From: Gedney, David
Sent: 16 June 2015 09:11
To: _planningadvice
Subject: FW: H21-0484-15

From: DGedney@sholland.gov.uk
To: mr.melton@hotmail.co.uk
Subject: RE: H21-0484-15
Date: Mon, 15 Jun 2015 13:15:47 +0000

From: Martin Melton [<mailto:mr.melton@hotmail.co.uk>]
Sent: 07 June 2015 20:31
To: Gedney, David
Subject: H21-0484-15

Proposed Block Plan
1 : 500

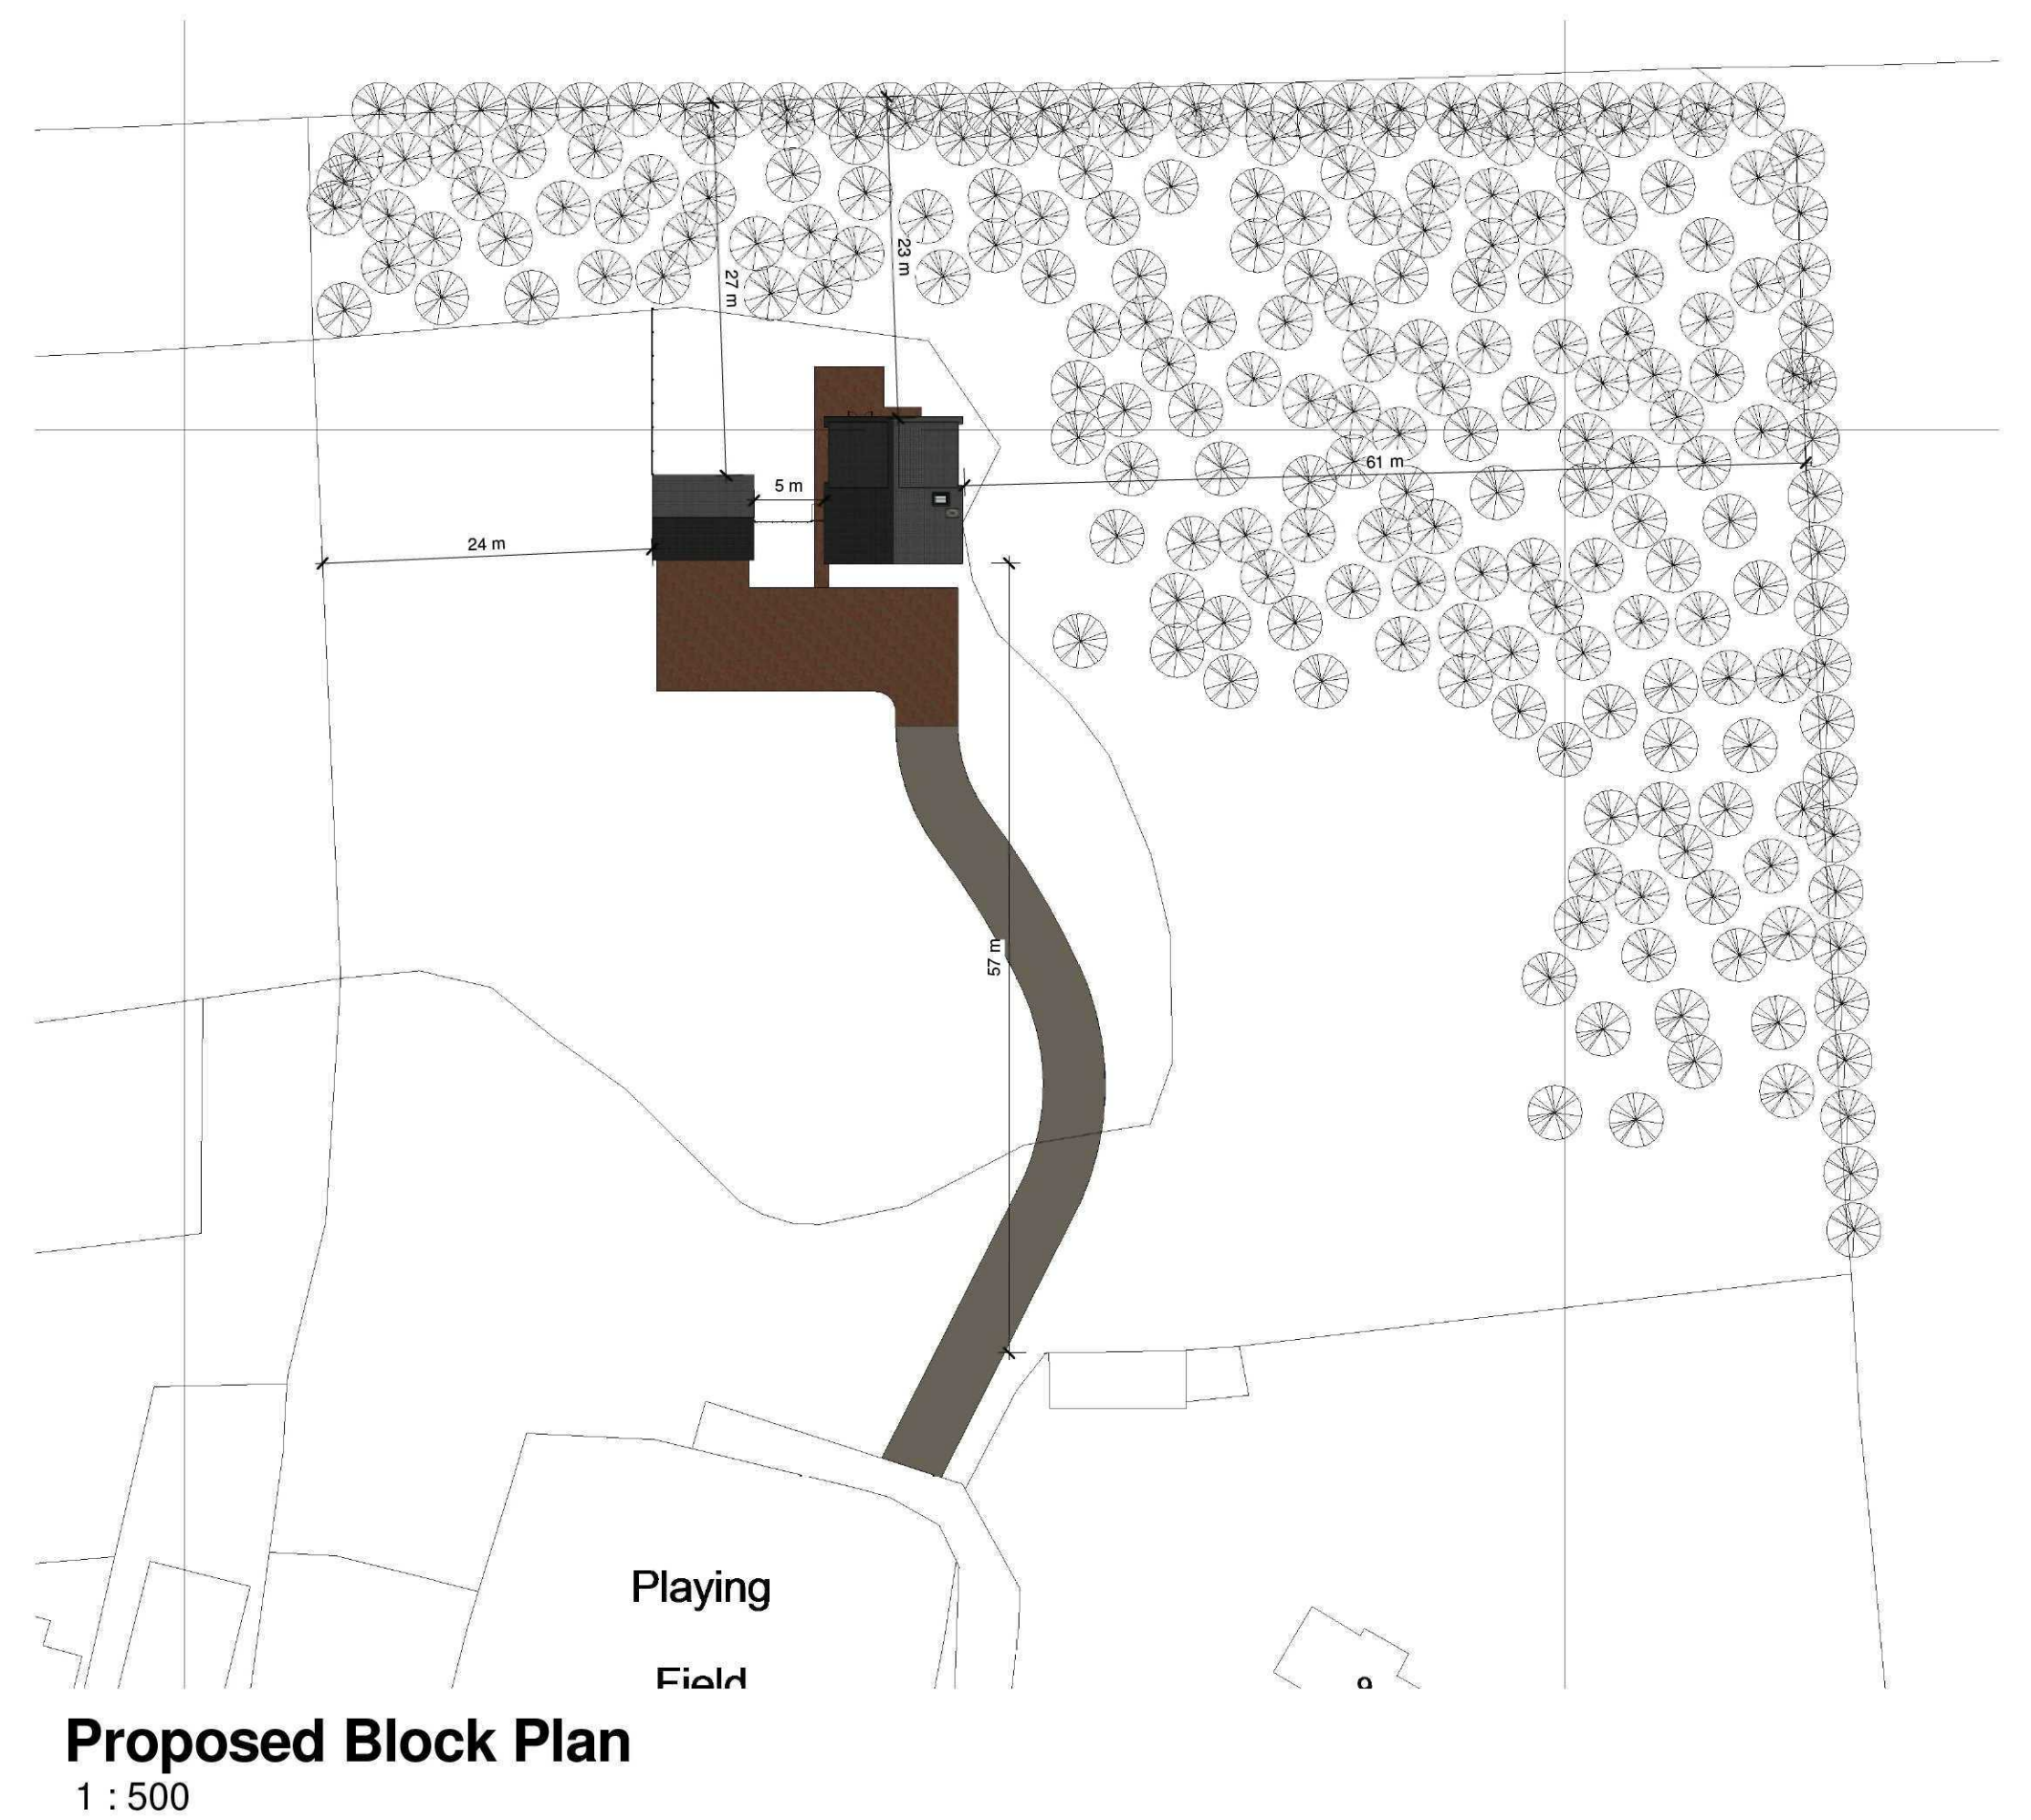
It is also noted that the proposed dwelling is within located close to trees along the northern boundary of the site. Please indicate why the dwelling has been positioned in this spot as opposed to a central location.

The reason the house is located further north is because to the west of the house there are 30ft conifers along the border up to the point The Shrublands property (south west) to where they currently have no fencing but intend on putting a 6 ft fence along the boundary. The height of the conifers blocks us out to any surrounding property. Including the bedroom windows.

That said, the dimensions were added to the plan after we had seen the plan and we did not intend on the property to be that close to the trees. Should we be allowed to build I would ask the architect to amend the plans and bring it 7-10 meters away from the tree line.
